Orsted Onshore Ireland Midco Limited

15: MEMORANDUM RESPONSE TO SUBMISSIONS RECEIVED

CUMULATIVE EFFECTS

Proposed Oatfield Wind Farm Project, Co. Clare: ABP
Case No. ABP-318782-24

Figure 12.8 Predicted extent of cumulative shadow flicker effect (cumulative scenario)

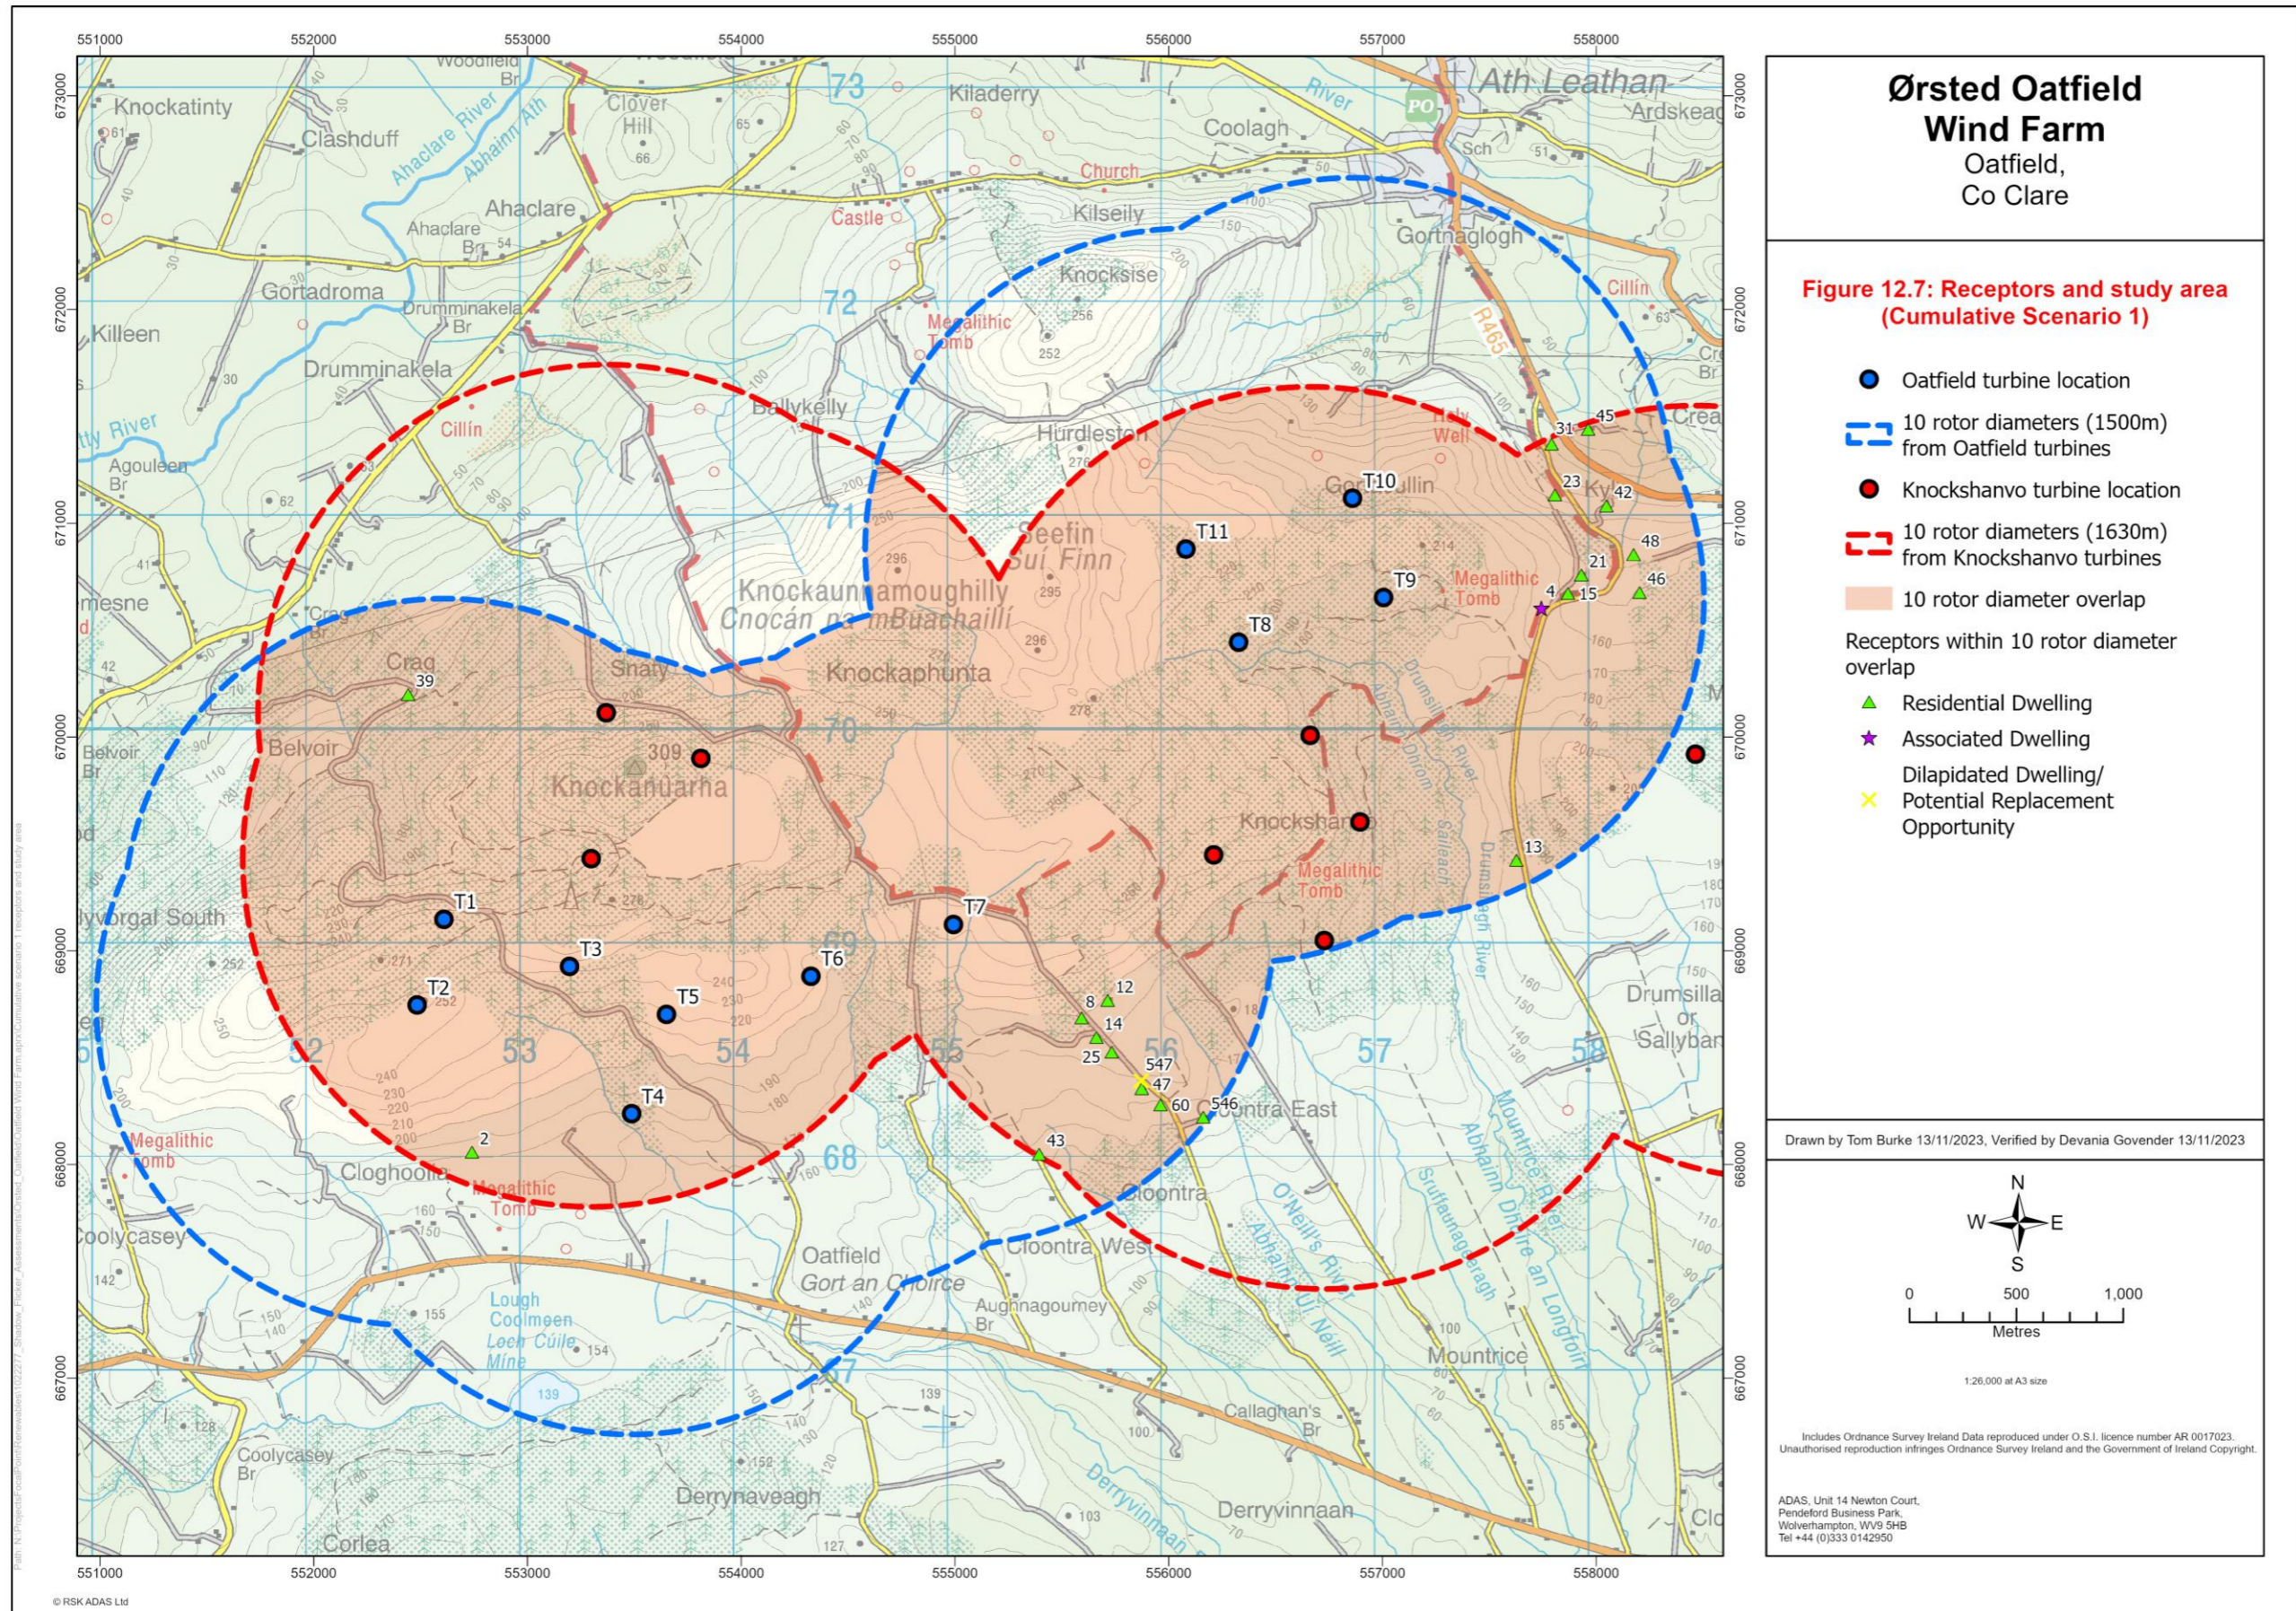
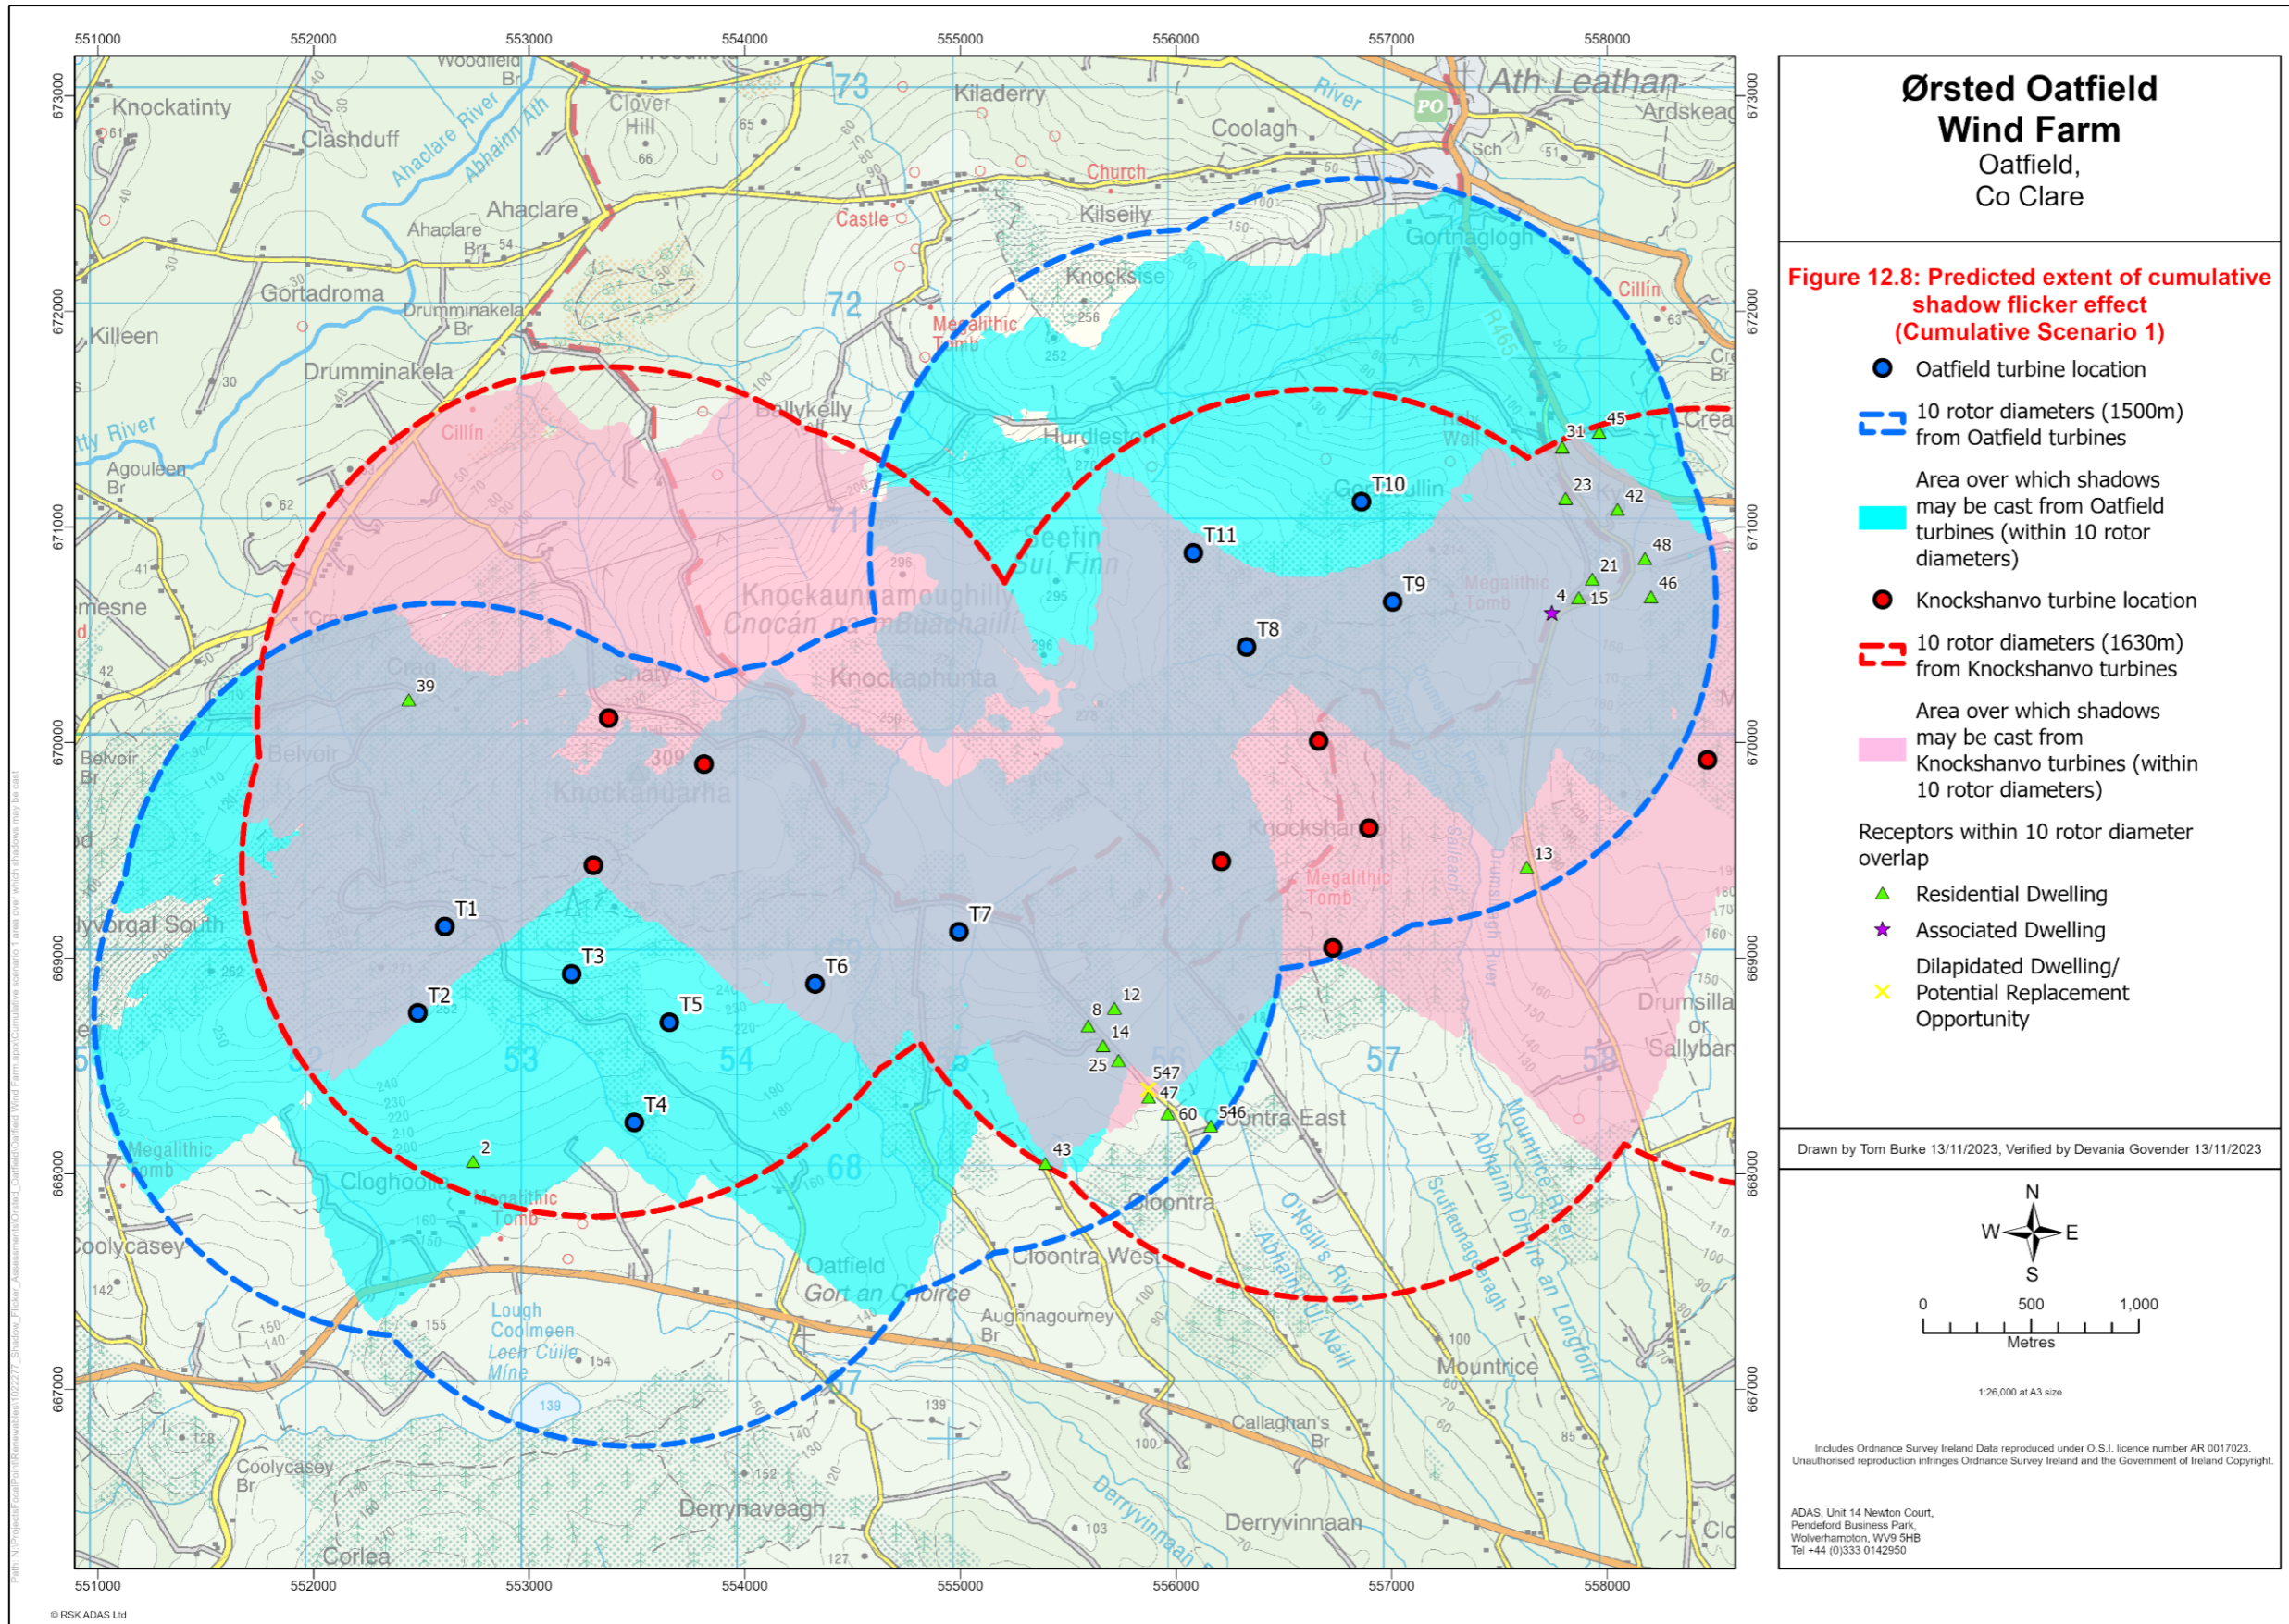
Several third-party submissions have raised concerns regarding the potential for combined shadow flicker impacts arising from the Proposed Development and the pre planning Knockshanvo Wind Farm.

Cumulative effects related to shadow flicker have been addressed in **memorandum no. 8**. Also, a thorough assessment of potential cumulative effects was conducted as part of the shadow flicker assessment presented in Section 12.9.1 of **EIAR Chapter 12**.

Potential cumulative effects were identified with the adjacent pre planning Knockshanvo wind farm and a cumulative shadow flicker assessment was therefore carried out, whereby the turbines of both the Proposed Development and the Knockshanvo wind farm were considered. At the time that the shadow flicker assessment was undertaken, the planning application for the Knockshanvo Wind Farm had not been submitted for planning, and no finalised detailed information is yet available. However, the planning application for Knockshanvo Wind Farm will likely consider the cumulative impacts from the Proposed Development, for which all relevant information has been submitted in the planning system. Nonetheless, **EIAR Chapter 12** for the Proposed Development presented an assessment of potential cumulative shadow flicker effects, using the latest known project details for Knockshanvo Wind Farm available at the time. As mentioned, it will be the responsibility of the Knockshanvo Wind Farm to demonstrate how it considers that Wind Energy Development Guidelines thresholds for shadow flicker can be achieved in practice through the cumulative operation of both sites.

At the time the shadow flicker assessment was conducted for the submitted EIAR, Ballycar Wind Farm was in the pre-planning stage, and proposed turbine locations and specifications were not publicly available. The planning application for Ballycar Wind Farm has since been submitted. Examination of the shadow flicker assessment carried out as part of this indicates that the 10 x rotor diameter shadow flicker study area for Ballycar Wind Farm does not overlap with that of the Proposed Development. There is therefore no potential for cumulative effects.
